11 Rev_7.apd

Please scan as an EOT confirmation and treat the comparative elevation and floor plans as substitutes for those submitted earlier this week. Don't process the site plan changes yet I have requested further information in relation to this plan.

Drg No: 190725-HT-F1-FP	Rev: A
-------------------------	--------

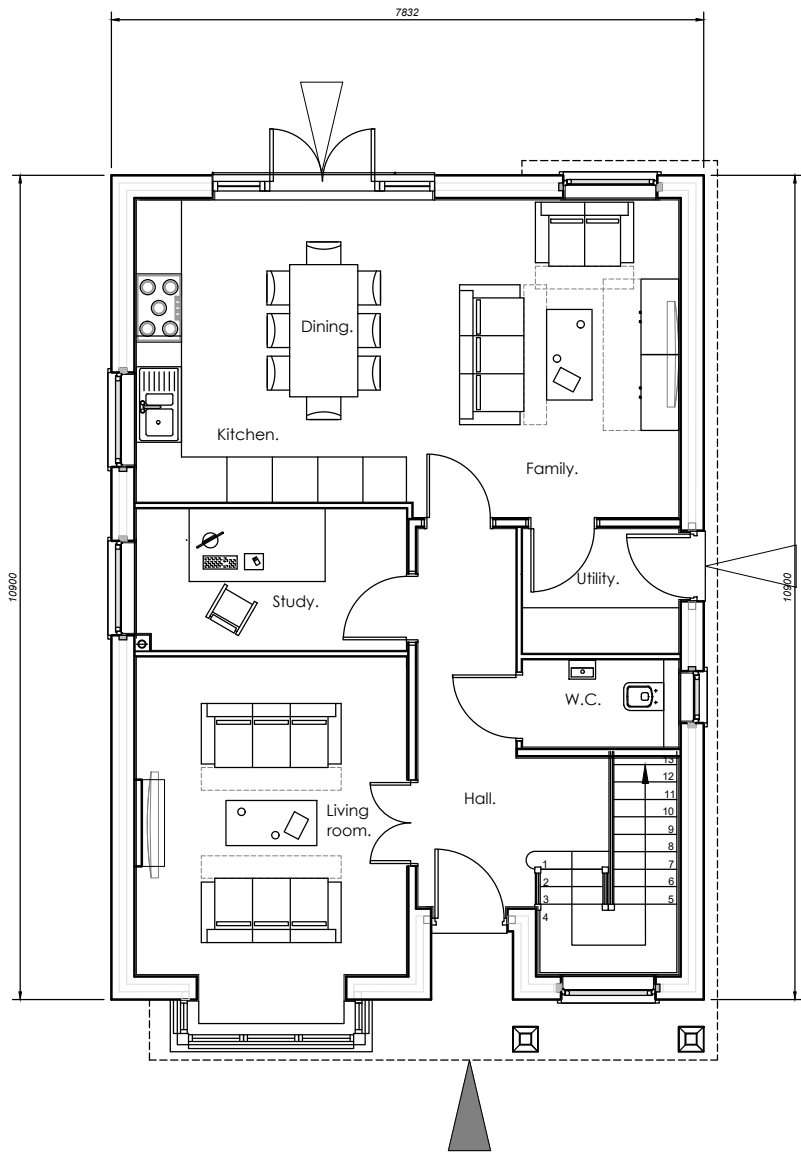
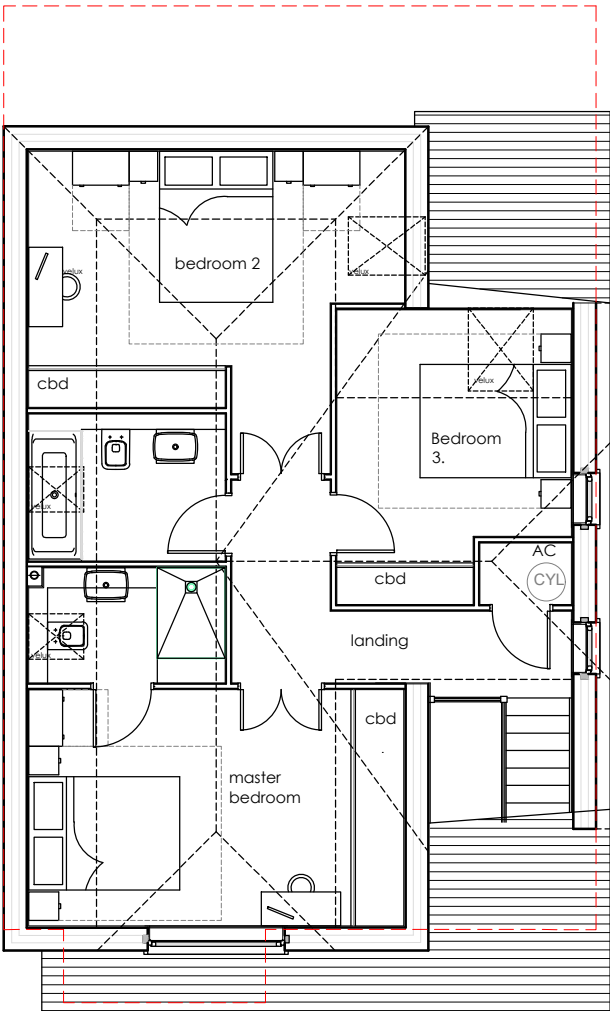
- Confirmation of the precise difference in the approved and proposed ridge and eaves heights
- Comparative dimensioned floor plans and elevations to demonstrate the differences between the 2 schemes in relation to plot 8
- Additionally the distance to neighbouring boundaries should be dimensioned on a site plan extract relating to plot 8 only

Please also find attached the site plan with dimensions from the plot 8 as requested yesterday as well as further plans and elevations of plot 8 detailing the differences between the approved and the proposed. This includes an extract from our construction section drawing showing the height of the sill of the rooflights facing the neighbours as 1837mm.
